Subject: 2022/62/92406/W Erection of 10 affordable dwellings, with access from Chapelgate and associated works, including resident play zone Land Adj, 67, Chapelgate, Scholes, Holmfirth HD9 1SX
Date: 07 September 2022 17:01:21

Sport England – Statutory Role and Policy

The Proposal and Impact on Playing Field

Name (462)-GWP-01-01-D-A-(PA)-0060

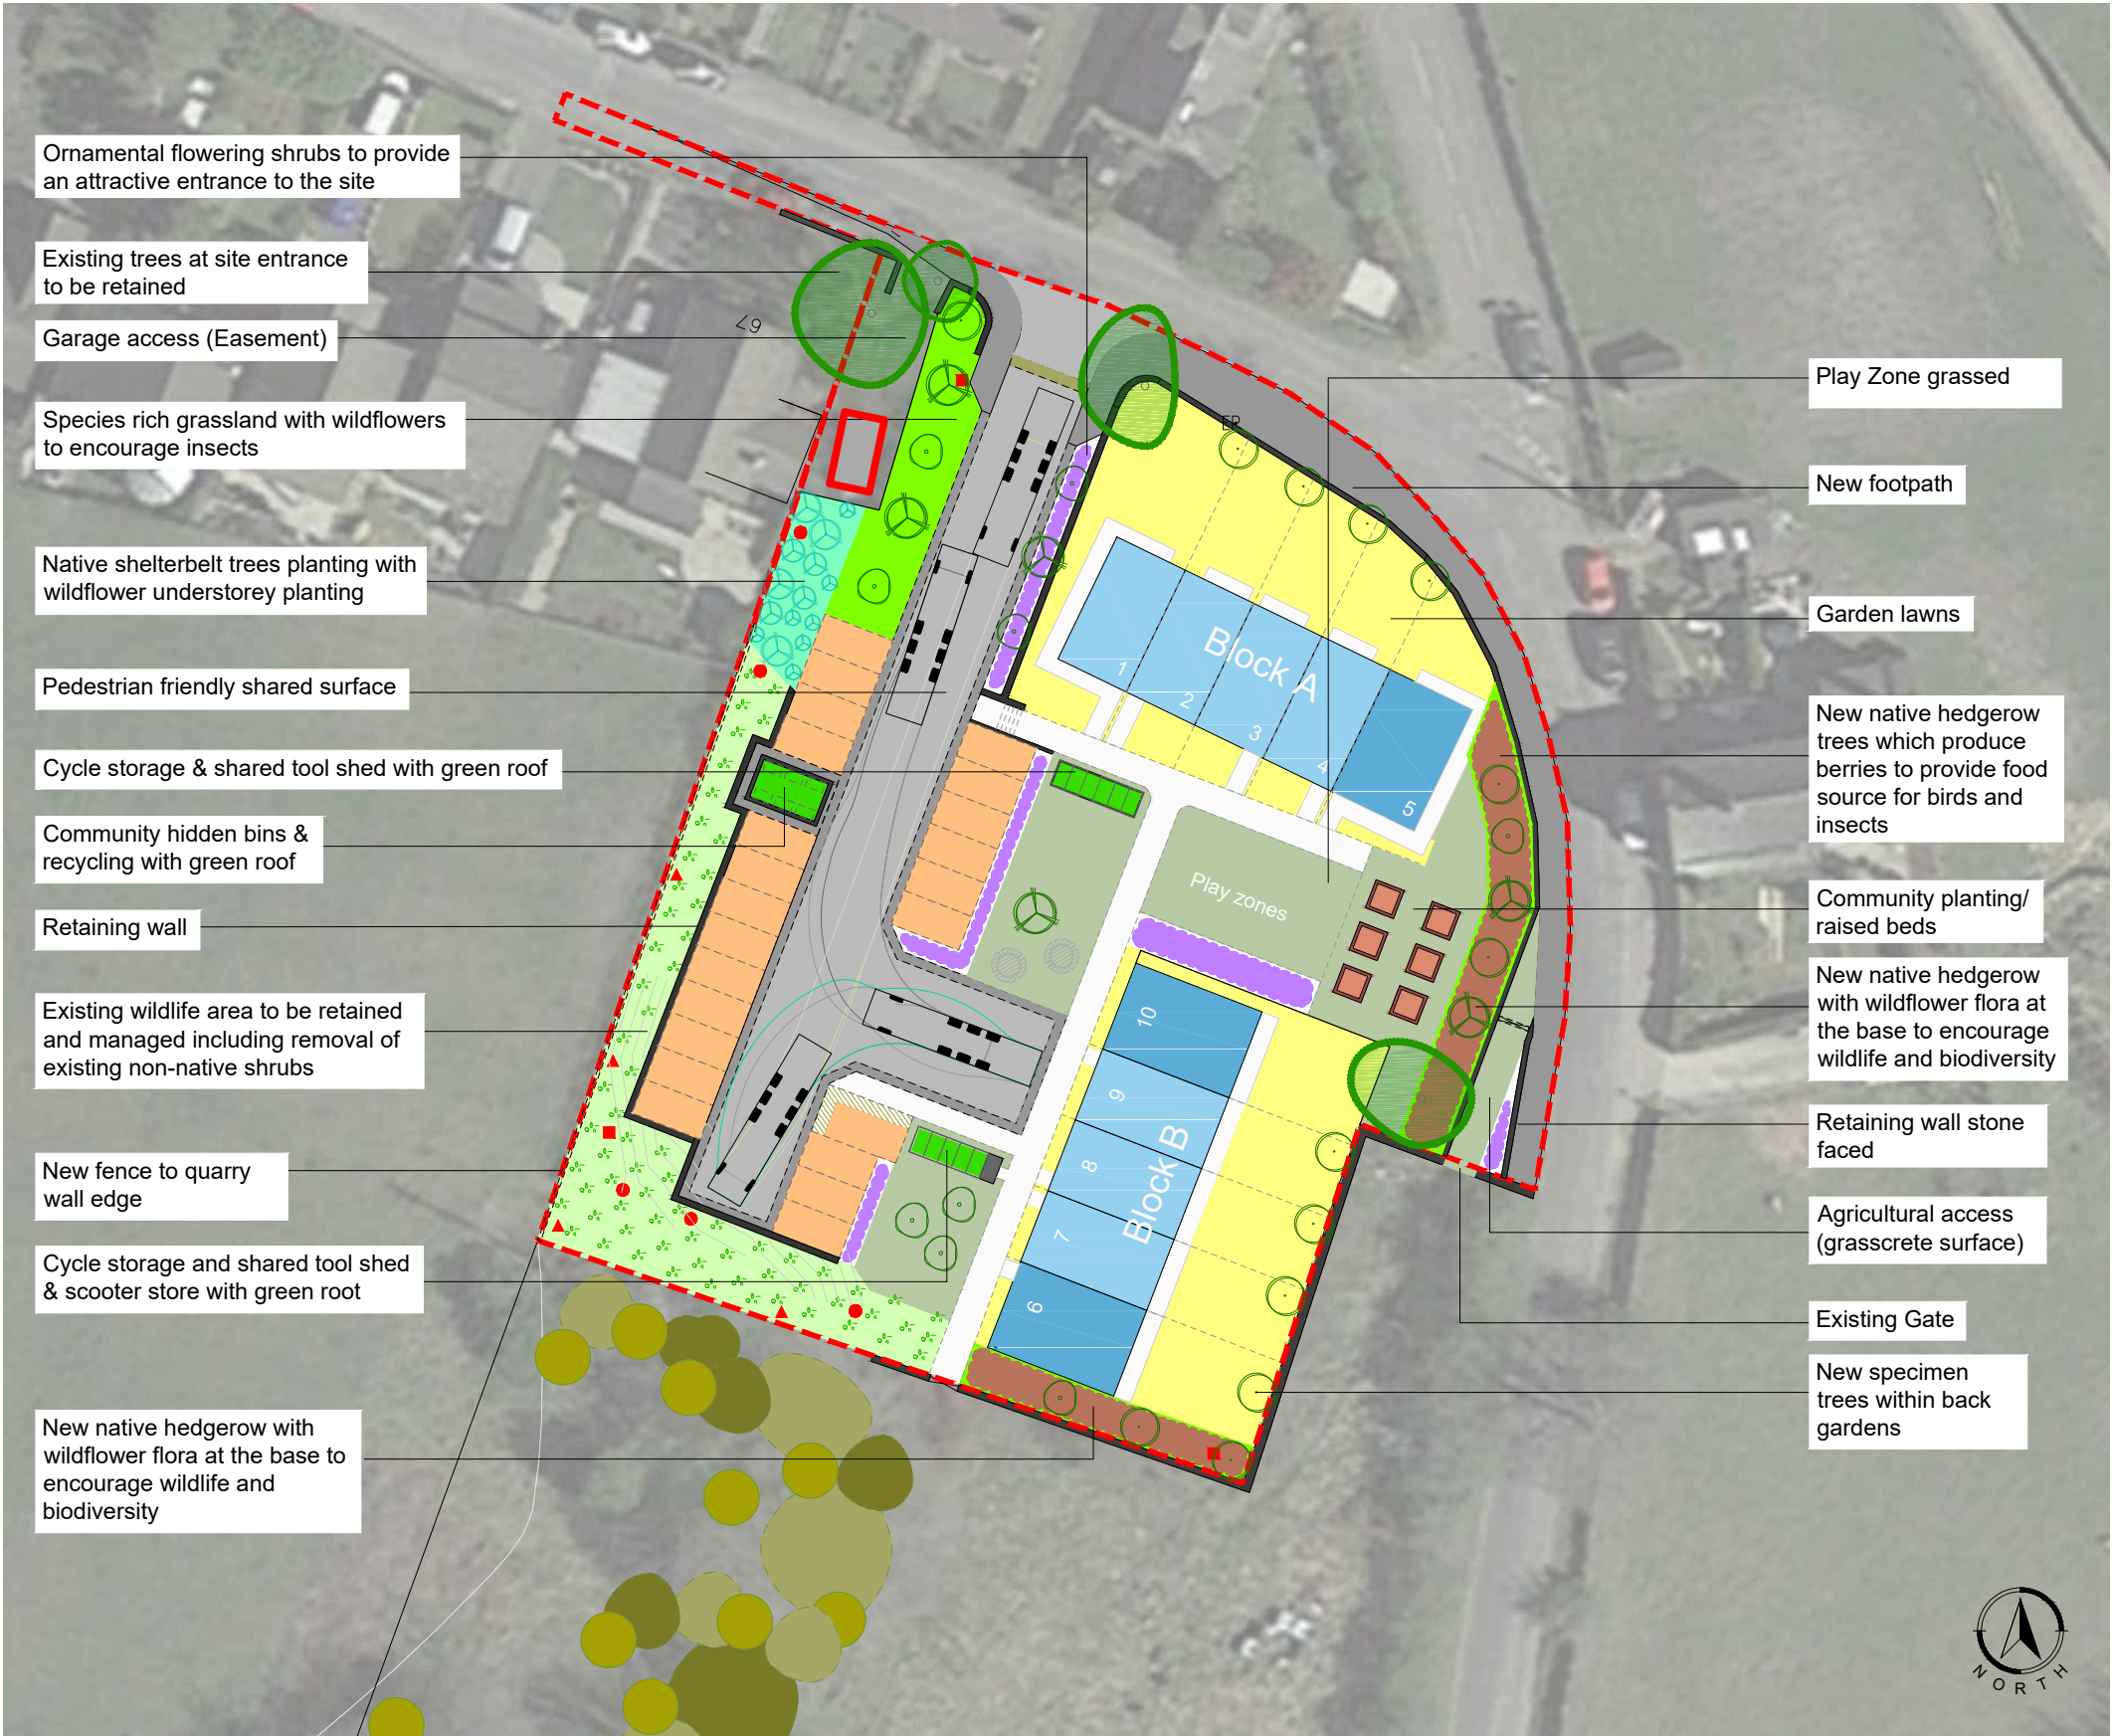
Whilst we remain of the view that the housing development will not in its own right have a prejudicial impact upon the playing field, the Ecological / Biodiversity Statement submitted in support of the application details an optional area of bio-diversity enhancement measuring 5.5m x 85.5m along the eastern edge of the playing field. The grassland / wildflower mix proposed would mean that this strip of the playing field could no longer be used for sport.

Whilst the strip of land in question does not appear to have been used to set out a playing pitch or part of pitch, the topography and shape of the playing field is such that it could be used this way if there was a requirement to re-orientate the existing pitch or set out pitches of a different size and number. As such Sport England considers that this aspect of the development does not conform with playing field policy

In light of the above, Sport England **objects** to the application because it is not considered to accord with any of the exceptions to Sport England's Playing Fields Policy or with Paragraph 99 of the NPPF.

For clarity, Sport England's objection would be resolved if the optional area of bio-diversity enhancement proposed for the playing field was omitted from the application.
